Date: 24 January 2025
Our ref: 478224
Your ref: EN010128

NSIP Reference: EN010128

Update of Natural England's Position on Air Quality

DRAWING NUMBER:
70090329-WSP-00-XX-RP-ENS-0702-P01-AN

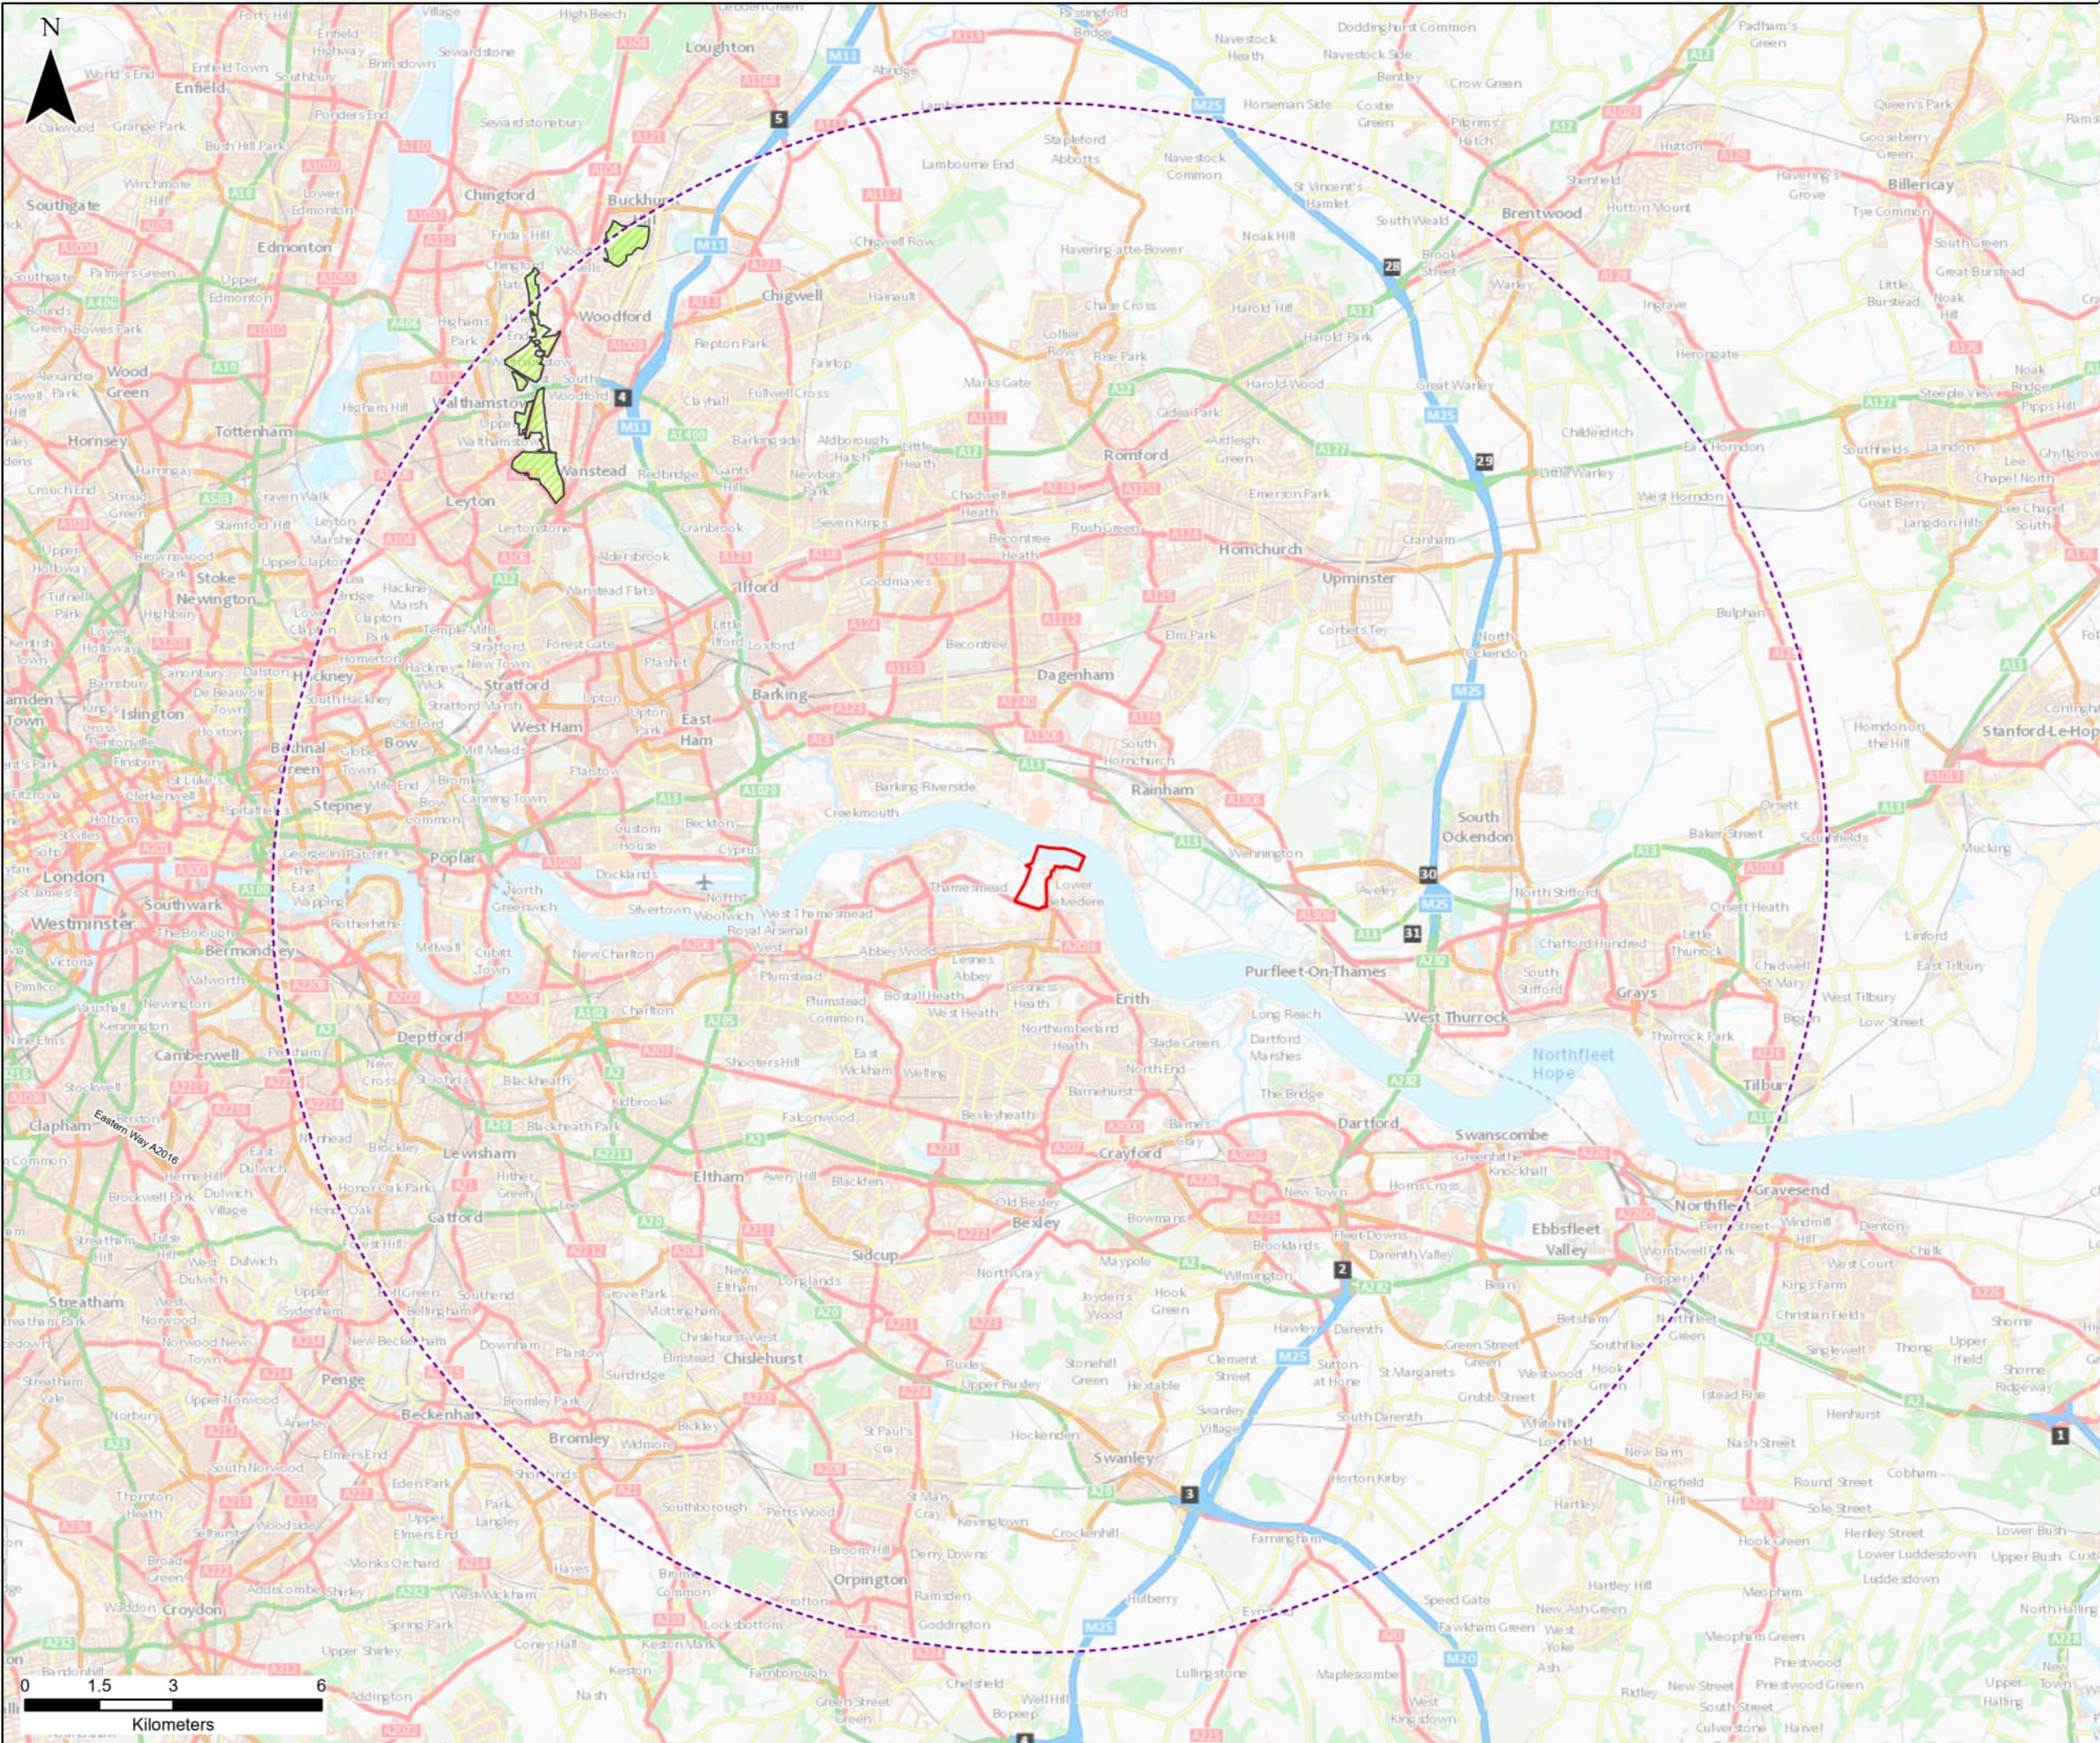
There is currently no in-combination assessment for Epping Forest SAC. We have historically advised that an in-combination assessment was necessary due to the original data in the ES demonstrating a PC of 0.75% of the relevant figure. As noted in Appendix B of the meeting minutes from 25th July 2024, the figure of 0.75% was deemed erroneous and revised down to 0.40%. The applicant argued that this figure was not practicable to factor into an in-combination assessment due to the distance from the site and size of the study area. Natural England agreed with this in our formal written representation.

However, this agreement was based on the Process Contribution in the ES/subsequent documents – which would be the difference between the emissions from the proposed scheme and Riverside 1&2 – not the Process Contribution as calculated by standard methods (emissions arising from the proposed scheme, regardless of baseline). Riverside 2 should be considered in the in-combination assessment – but it is accepted that if the proposed development goes ahead, it will not form part of pollution at Epping as Riverside 2 is an unimplemented consent.

- Given NE is no longer confident that the cited percentage from the Project alone is based on the true emissions from the proposed scheme itself, a reconsideration of the in-combination assessment should be made.
